Application for a non-material amendment following a grant of planning permission.

12 No. Social dwellings for Angmering Community Land Trust, including two communal bike stores, a pedestrian mews and orchard. Departure from the Development Plan.

| Reference number: | A/219/17/P |

Changes to certain materials/details , namely:-

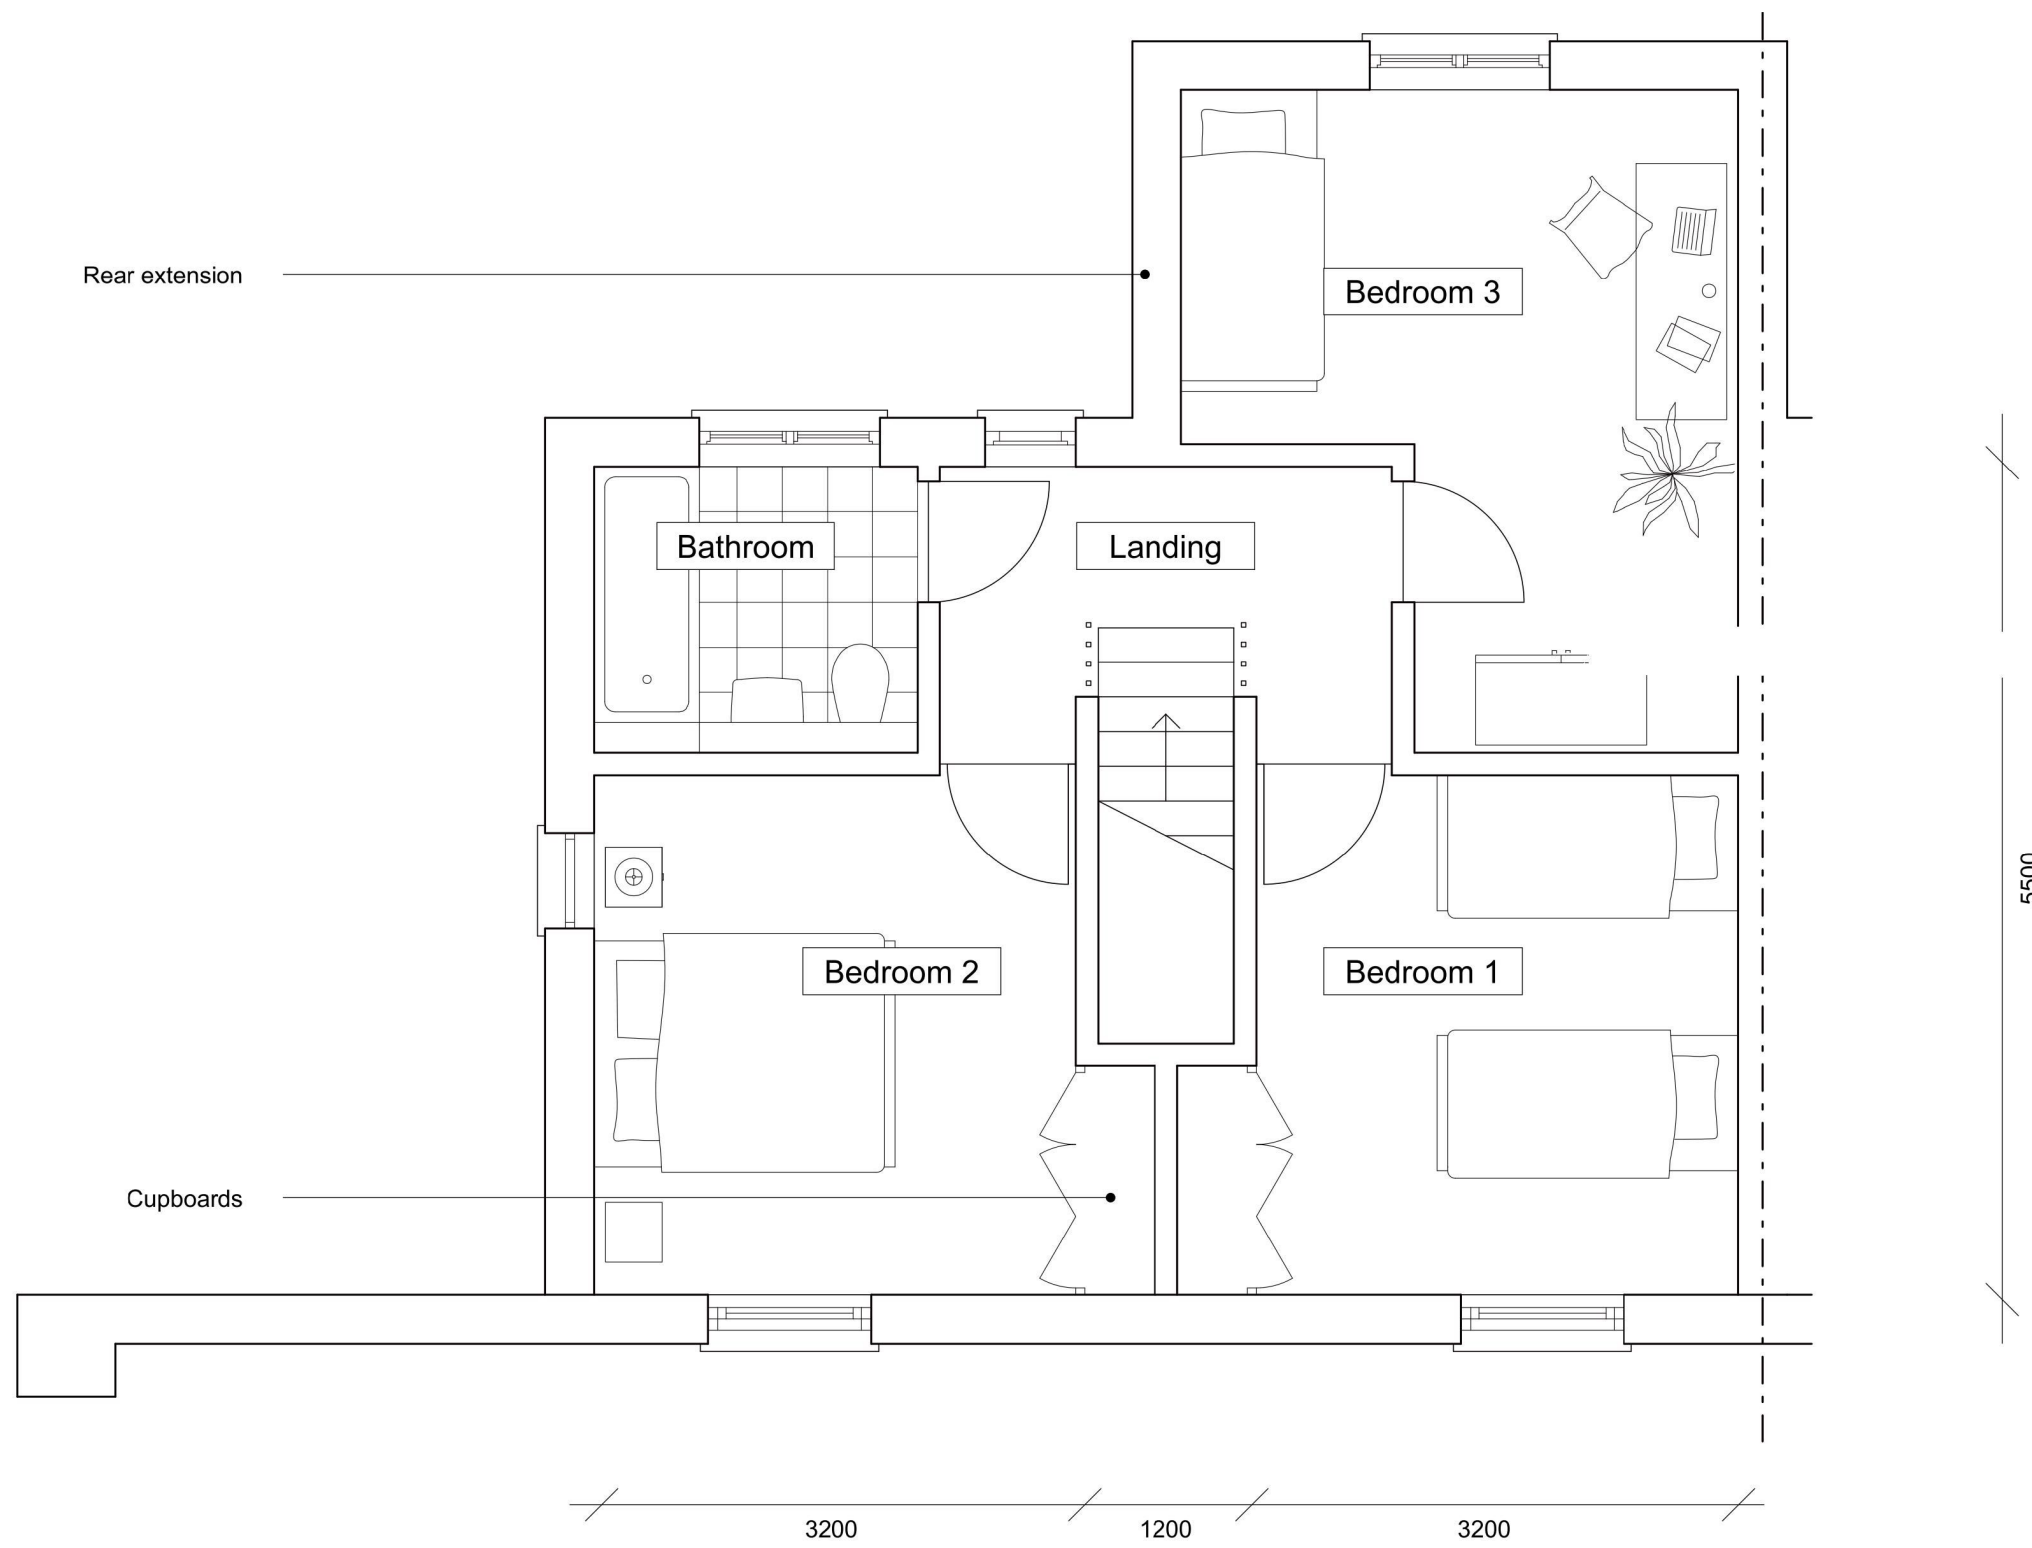
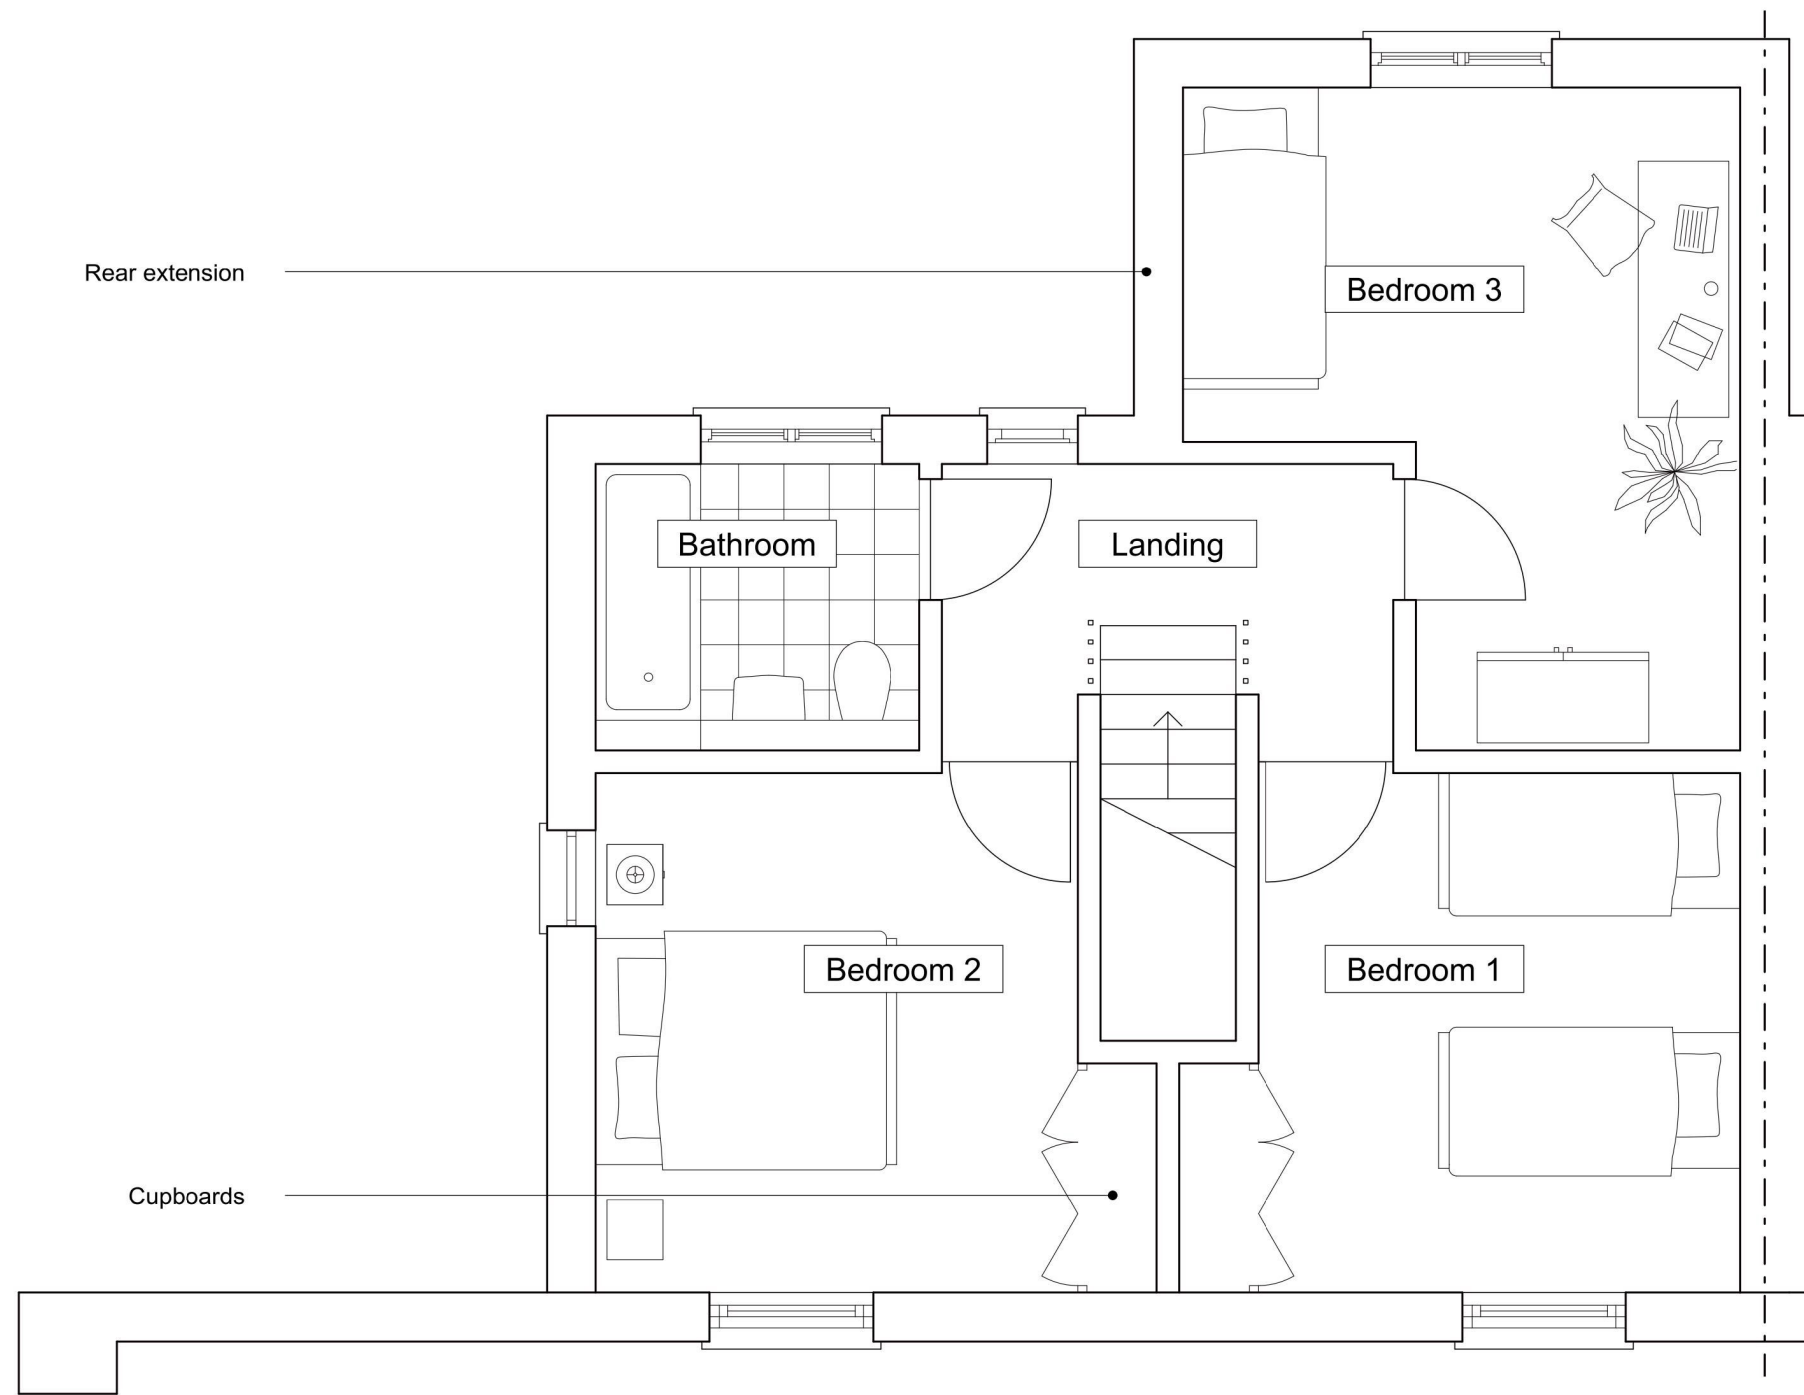
6Front doors to be GRP composite PAS24 while providing the same overall appearance. Reason: Development cost and on-going burden of cyclical maintenance.  
7 - Lintol treatment amended where noted on drawings: RSJ detail changed in favour of homogenous brickwork, & window jointol treatment amended as noted
